**CSI-Cartesian Surveys Inc.**  
PO Box 44414, Rio Rancho, NM 87174  
896-3050 Fax 891-0244

April 6, 2026

**Re: Final Plat Review for Proposed Subdivision of Lot 1-A, Block 1, of Tijeras Park Addition, being comprised of Remaining Portions of Lots 1 thru 12, Block 1, Tijeras Park Addition and A Portion of Vacated Roma Avenue NE Right-of-Way**

**Plat for  
Lot 1-A, Block 1  
Tijeras Park Addition  
Being Comprised of  
Remaining Portions of Lots 1 thru  
12, Block 1, Tijeras Park Addition  
and A Portion of Vacated Roma  
Avenue NE Right of Way  
City of Albuquerque  
Bernalillo County, New Mexico  
March 2026**

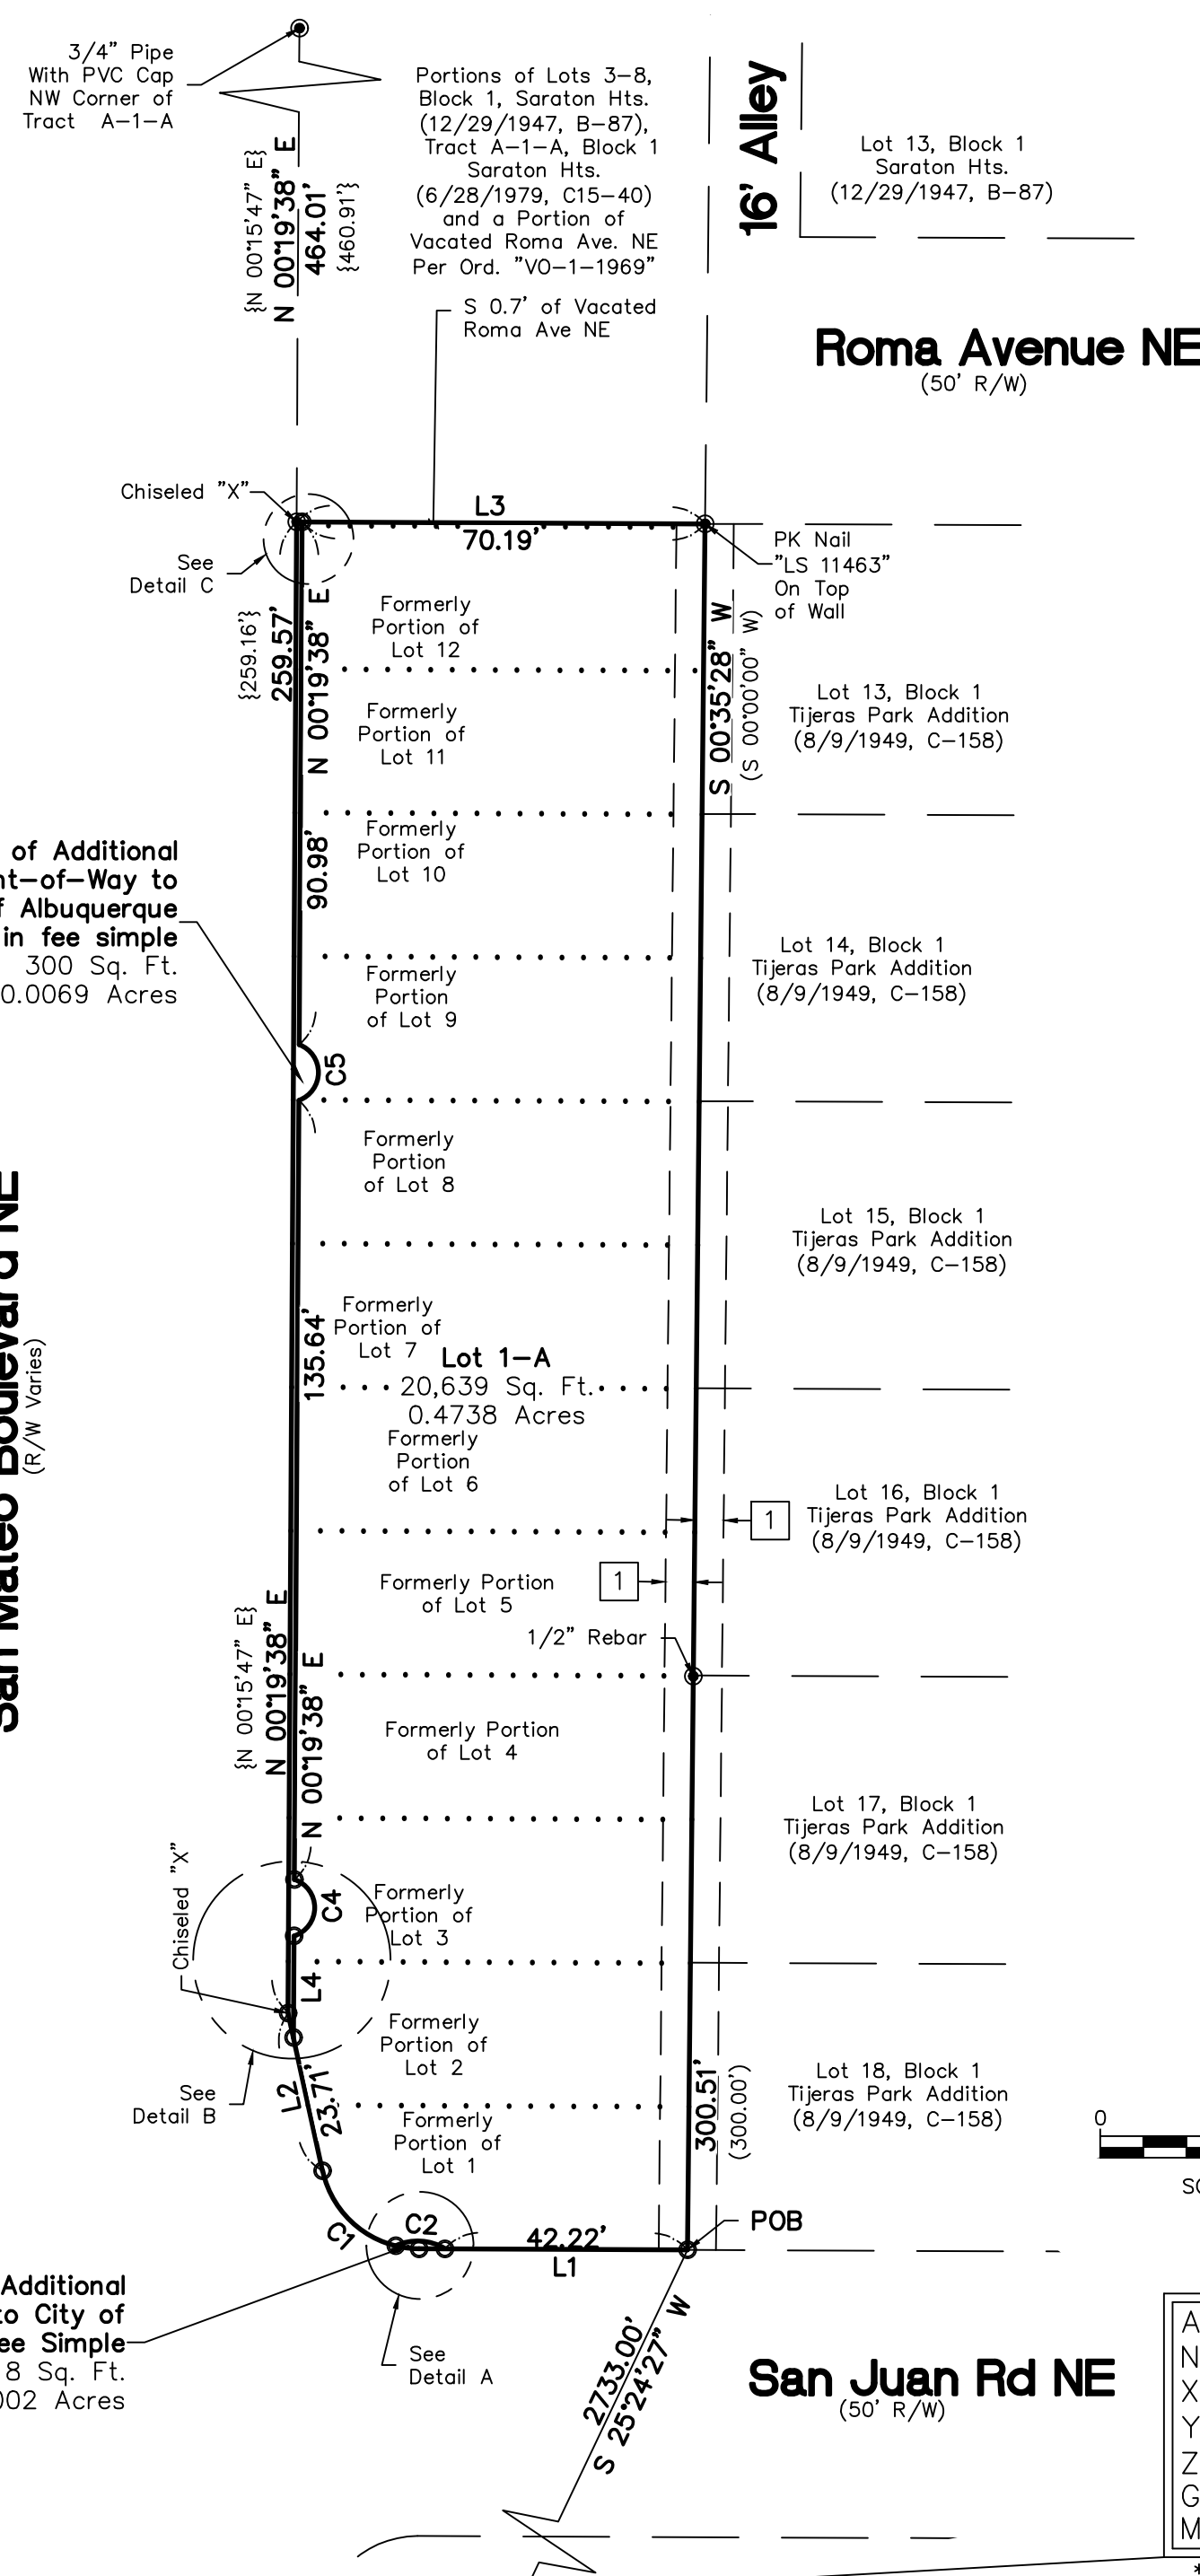
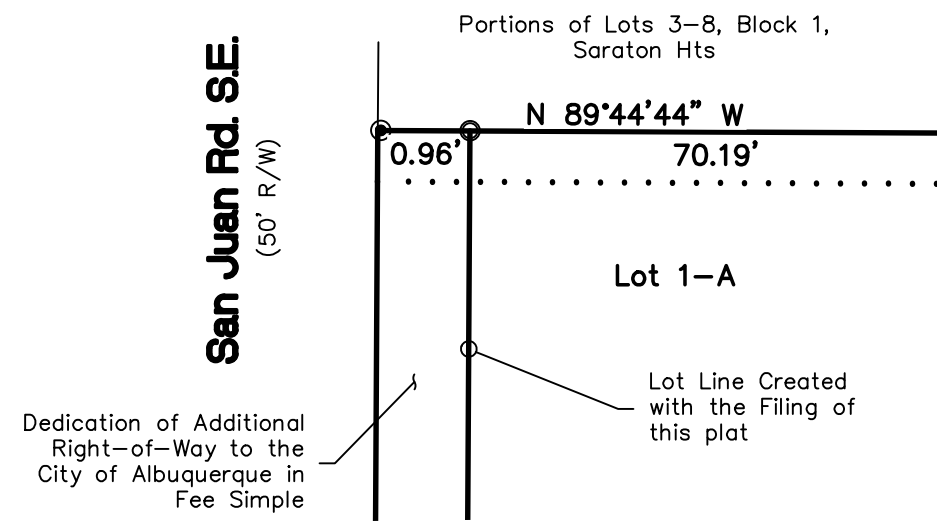
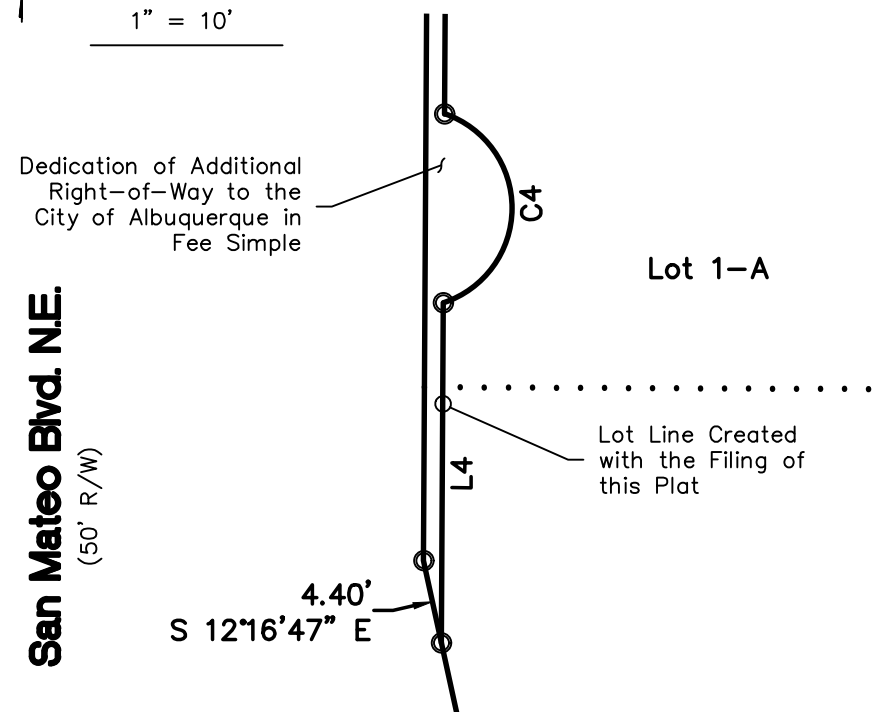
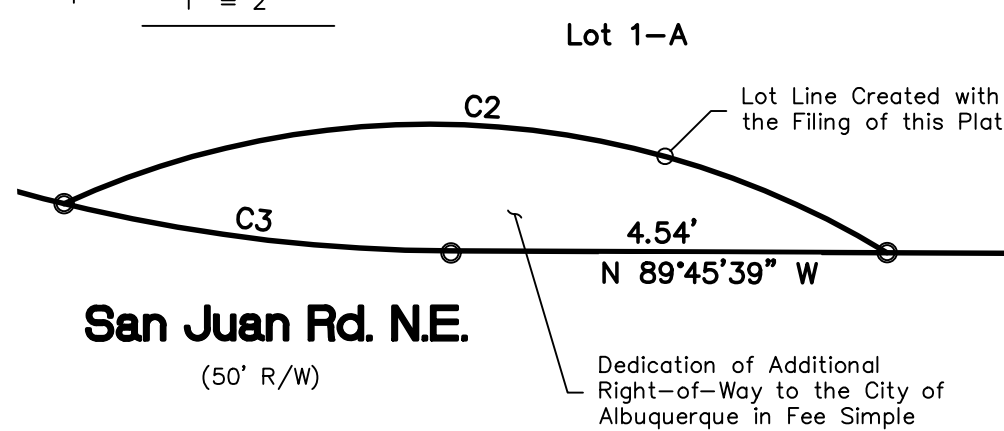
1. Transportation has no objection to the lot consolidation. 6' sidewalk is required along San Mateo Blvd. fronting this property with a minimum 4' clear around obstructions such as light poles. ROW dedication may be required.
2. Any unused drive pads shall be removed and filled with curb, gutter and sidewalk.
3. For future development a TCL will be required prior to building permit or site plan for building permit.

Noted, 4-foot clearance for sidewalk is provided for with dedication of additional right-of-way to San Mateo Blvd and San Juan Road NE.
